**City of Portland, Maine - Building or Use Permit Application**  
 389 Congress Street, 04101 Tel: (207) 874-8703, Fax: (207) 874-8716

Permit No. <b>02-0428</b>	Issue Date	DBL: 083C A012001
---------------------------	------------	-------------------

Past Use: single family	Proposed Use: single family DEMO and replace existing 10' x 32' deck, no stairs	Permit Fee: \$37.00	Cost of Work: \$1,553.15	CEO District: 1
Proposed Project Description: DEMO and replace existing 10' x 32' deck		FIRE DEPT: <input type="checkbox"/> Approved <input type="checkbox"/> Denied	INSPECTION: Use Group: <b>RS</b> Type: <b>5B</b>	
		Signature: <i>[Signature]</i>		Signature: <i>[Signature]</i>

RE: Judy O'Brien – Great Diamond Island

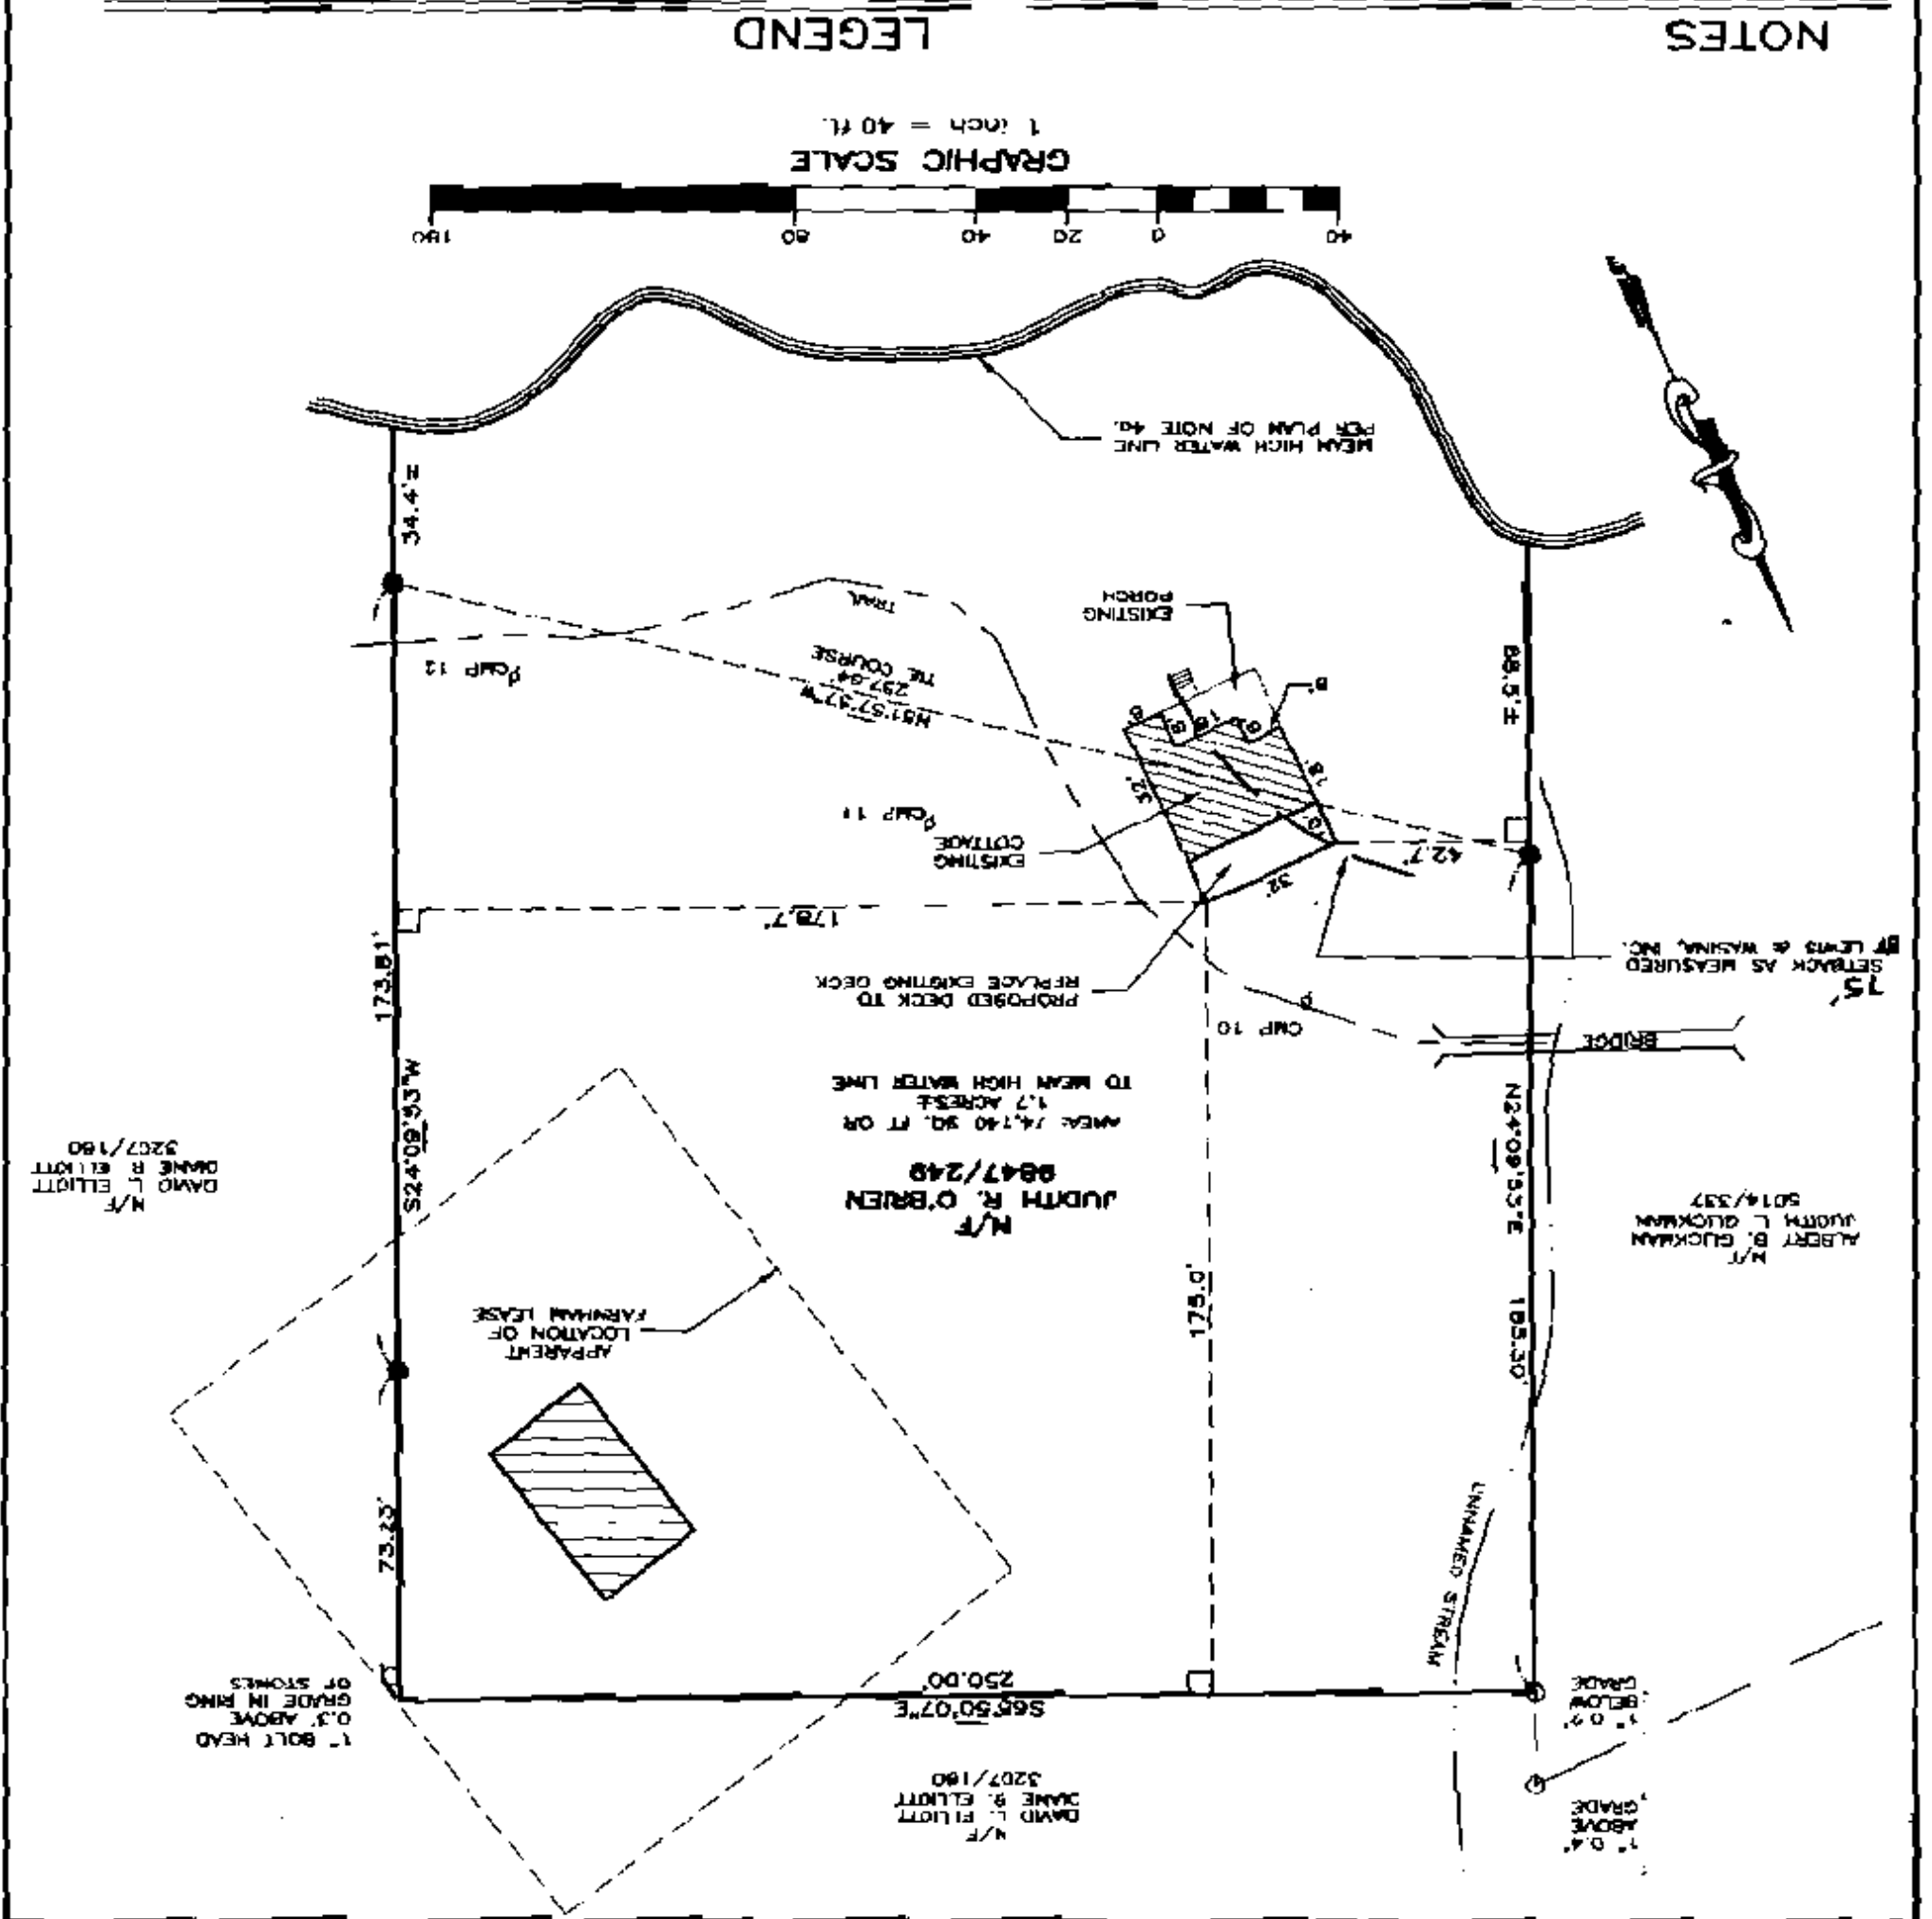
Guards must be 36" in height with openings LESS than 4 "

Enclosed please find a revised plan showing the 75 foot setback line from the normal high-water mark. This portion of line was accurately located by Lewis & Wasina, Inc., as well as the existing structure. The following calculations show that we are well within the 30% expansion allowed.

Total area of existing structure within 75 foot setback	479 sq. feet
479 X 30% = sq. feet allowed expansion	
Total area of expansion requested	46 sq. feet
